Colston Budd Rogers & Kafes Pty Ltd

4 November, 2019

RE: QANTAS FLIGHT TRAINING CENTRE (SSD 10154)
RESPONSE TO MATTERS RAISED BY DPIE

PROPOSED PARKING SUMMARY

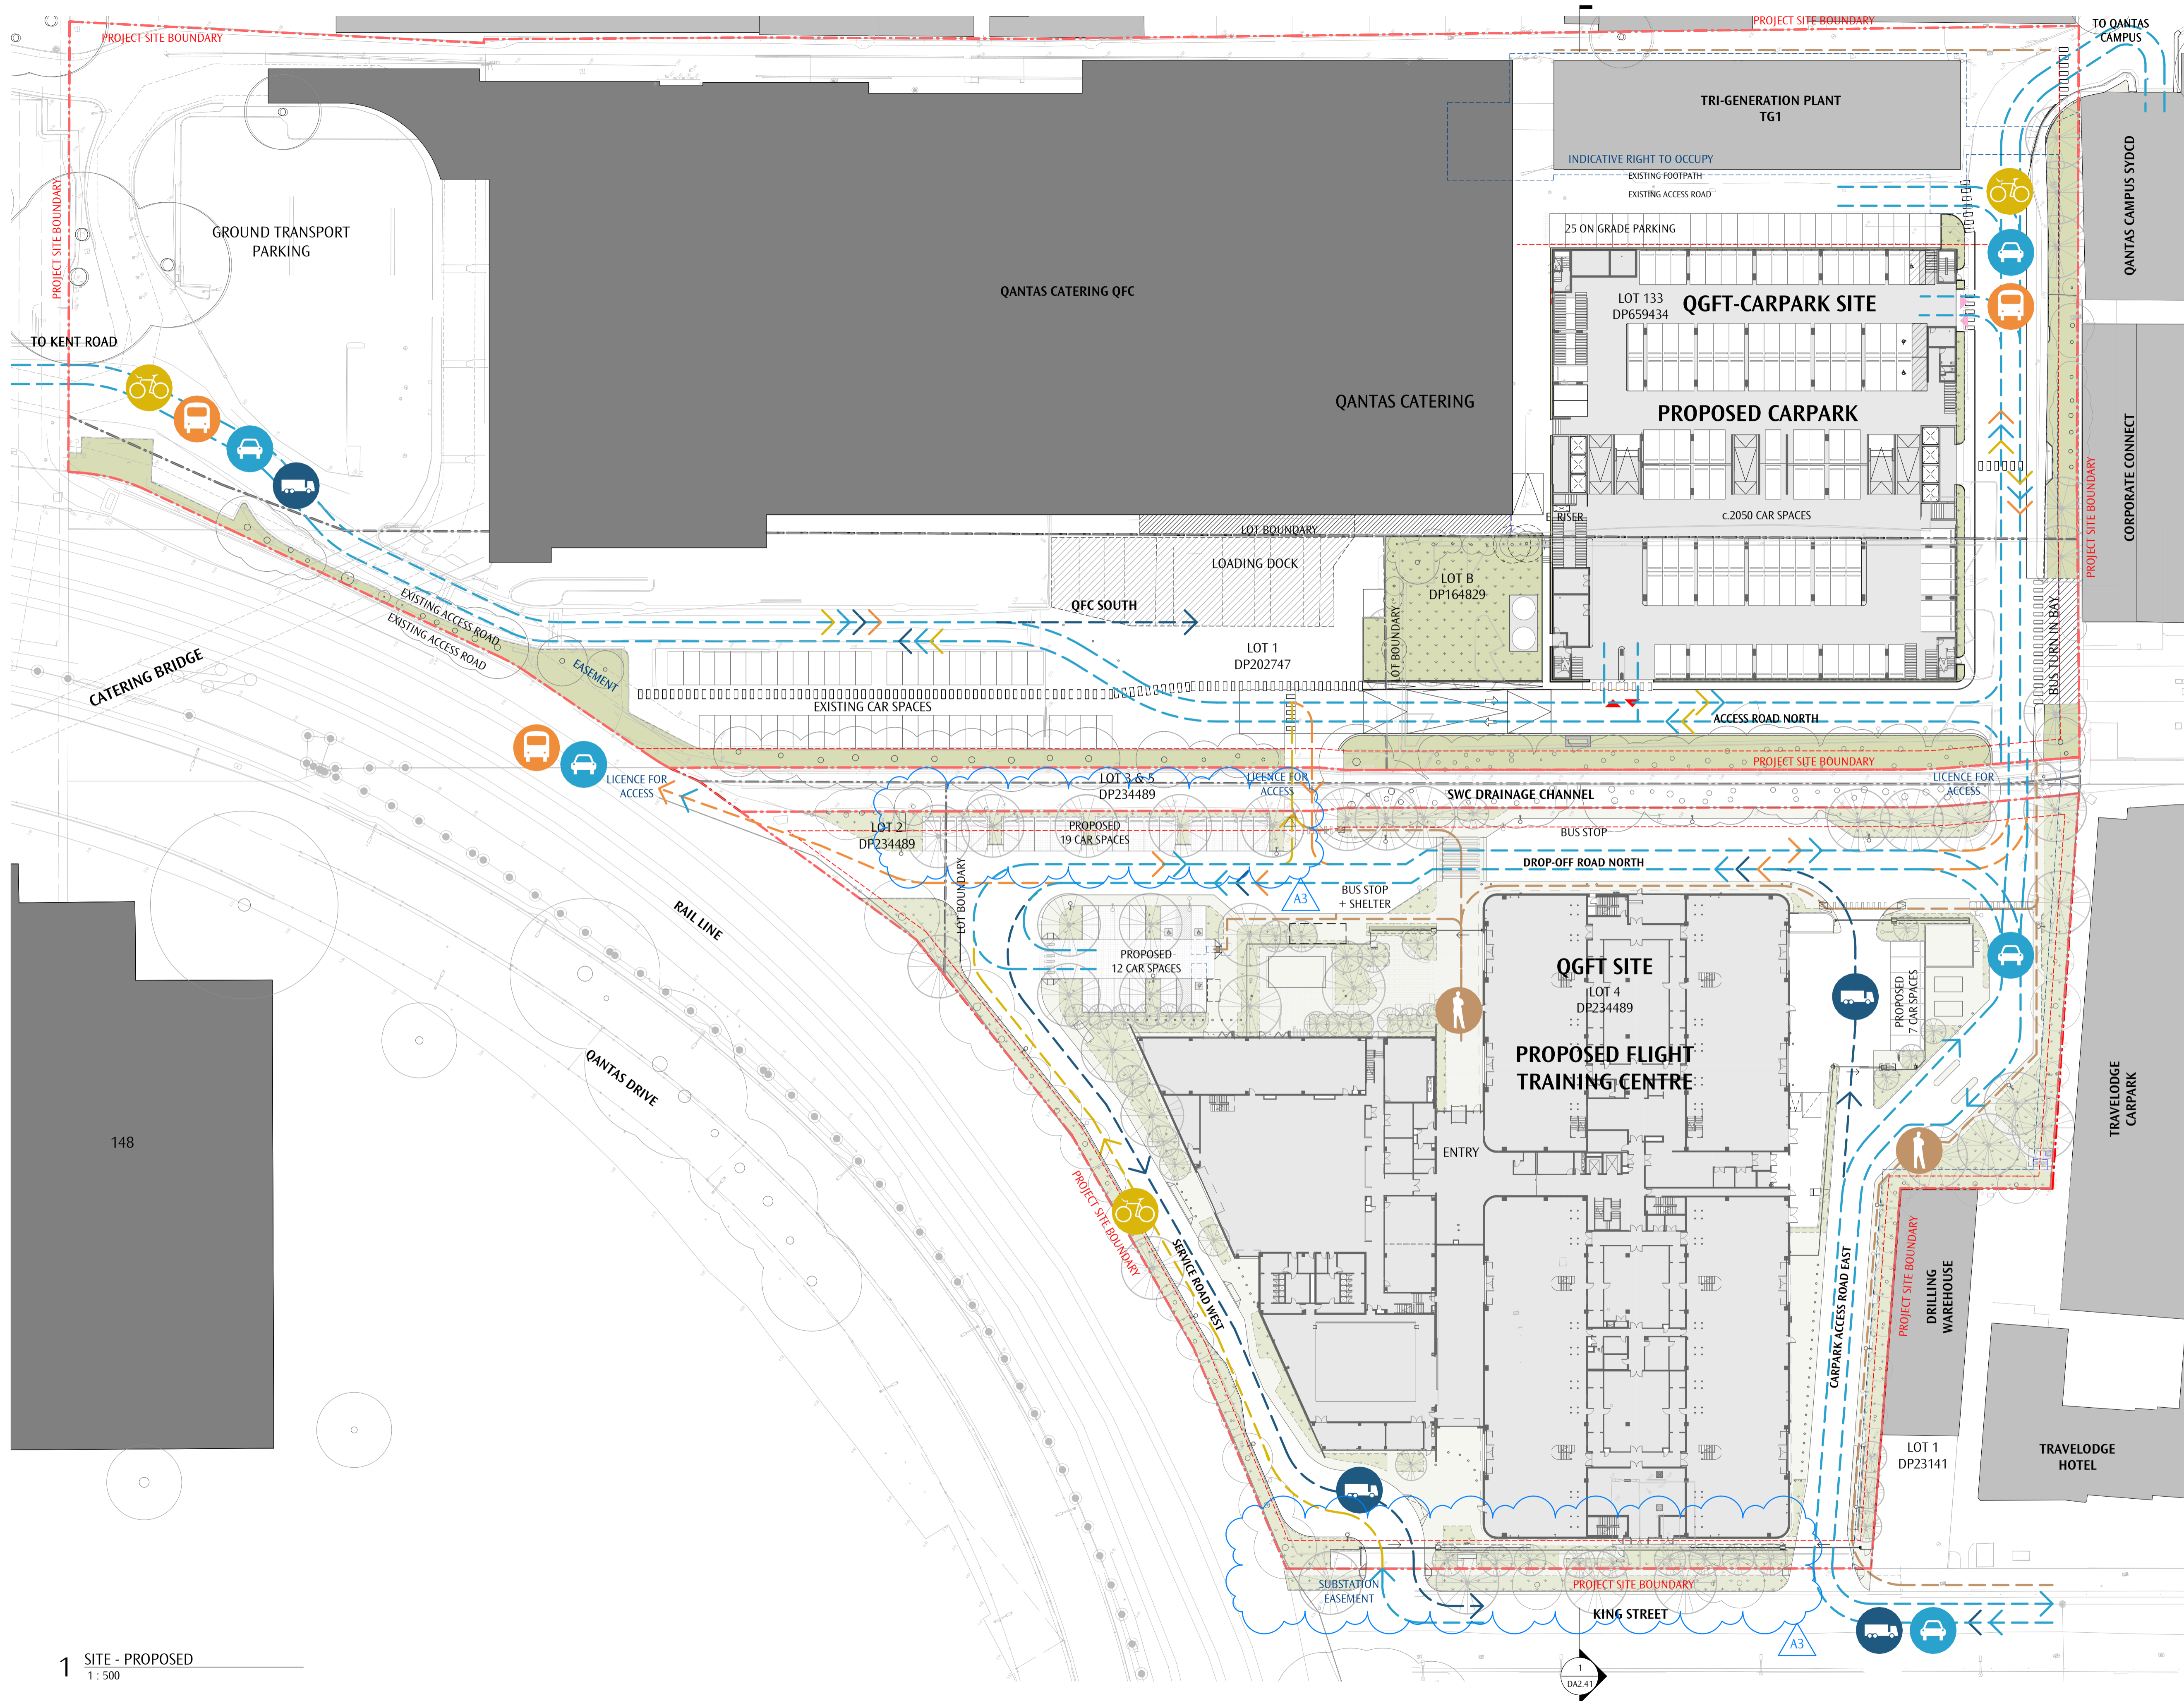
- Section 2.2 of the RTS provides the revised parking numbers with a total of 2,097 spaces, however, the Department notes there may be a discrepancy in the overall parking numbers as it appears the 38 car spaces has been added twice (i.e. $(786 + 1,272 = 2,058) + 38 = 2,097$). Please clarify where the second lot of 38 spaces are located on-site and if the overall additional net gain of parking is 97 spaces. To clarify there is a total of 2,058 car parking spaces across the Project – Stage 1 includes 748 car parks in the multi-deck car park and 38 car parks at grade and Stage 2 includes 1,272 additional car parks in the multi-deck car park. The second calculation of the 38 at grade car parking spaces is incorrect and not proposed as part of the Project.

9. In response to the above matter, the total number of parking spaces for the development (within Trigen and King Street North areas) is 2,097 spaces.
